Date: 08/16/2024

Re: Roof Truss Issue
Location: Lot 17 Griffon Pointe (168 Grand Griffon Way, Lillington, NC)
JDS Project No.: RDU2408401
Date of Inspection: 08/16/24

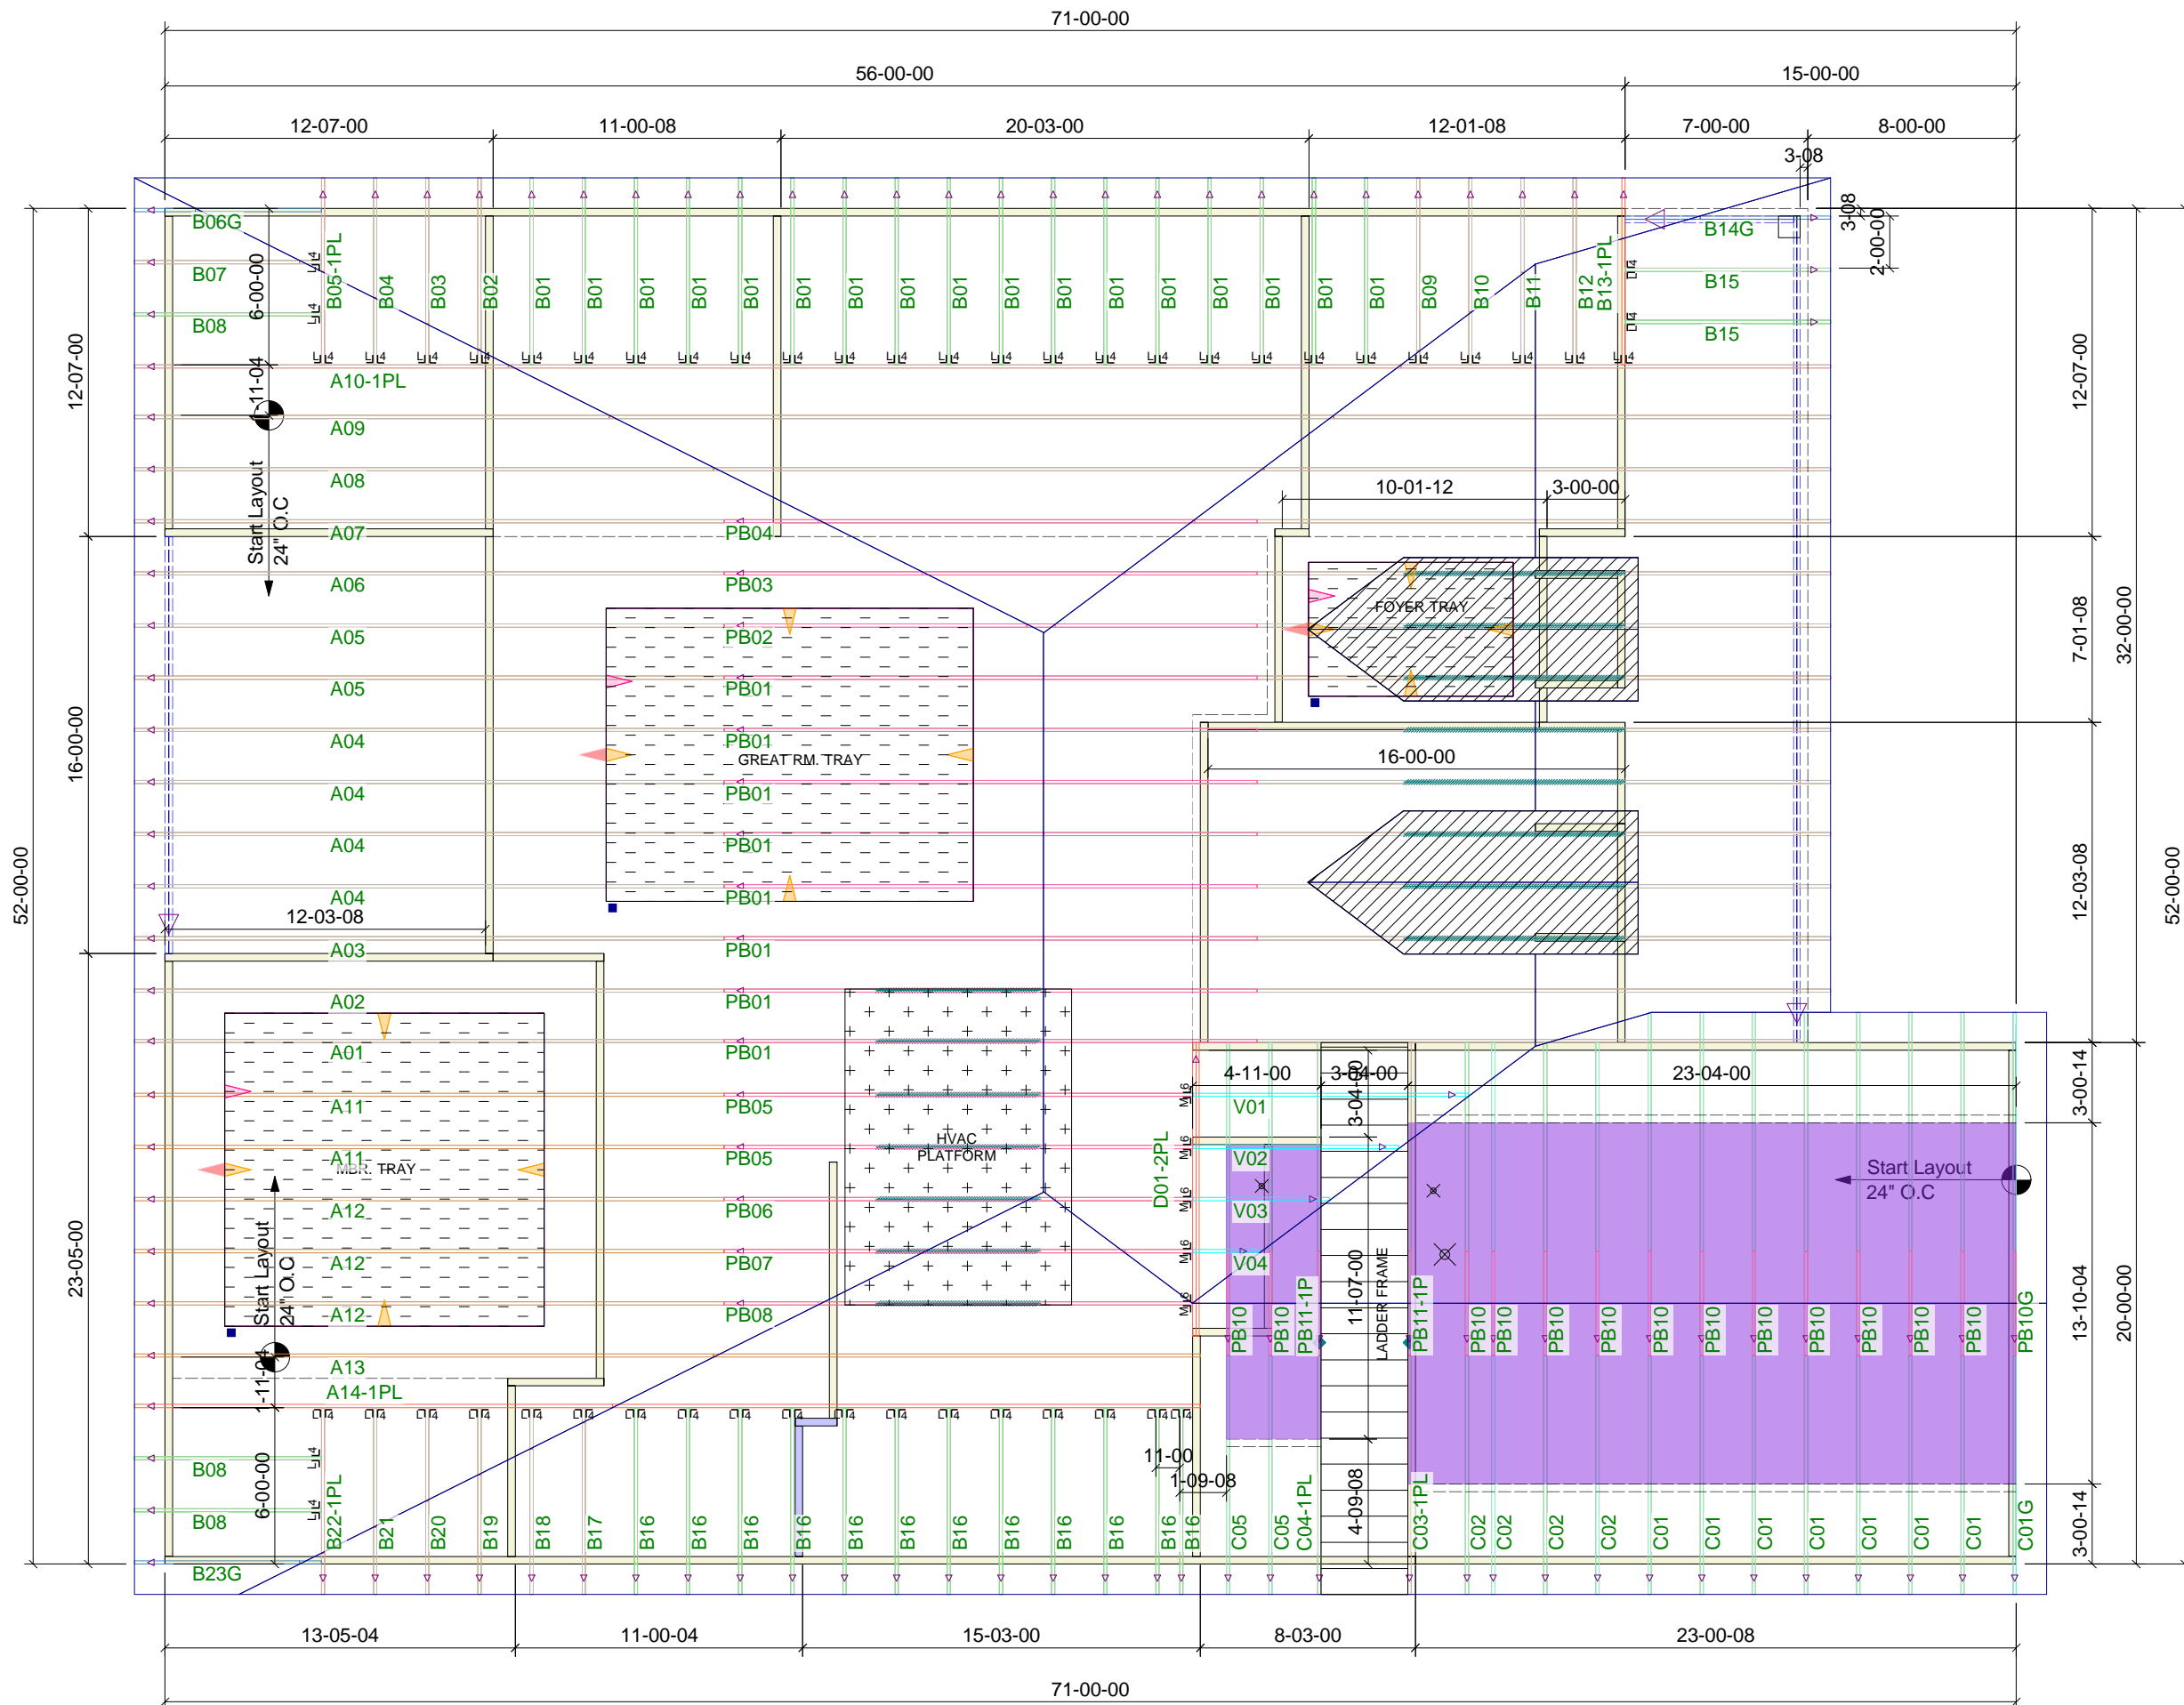
The client requests an evaluation of the V02 through V07 roof trusses that have been modified to fit. The trusses have been cut on one side to fit against an adjacent truss.

Based on our on-site observations and review, the trusses are adequate as installed.
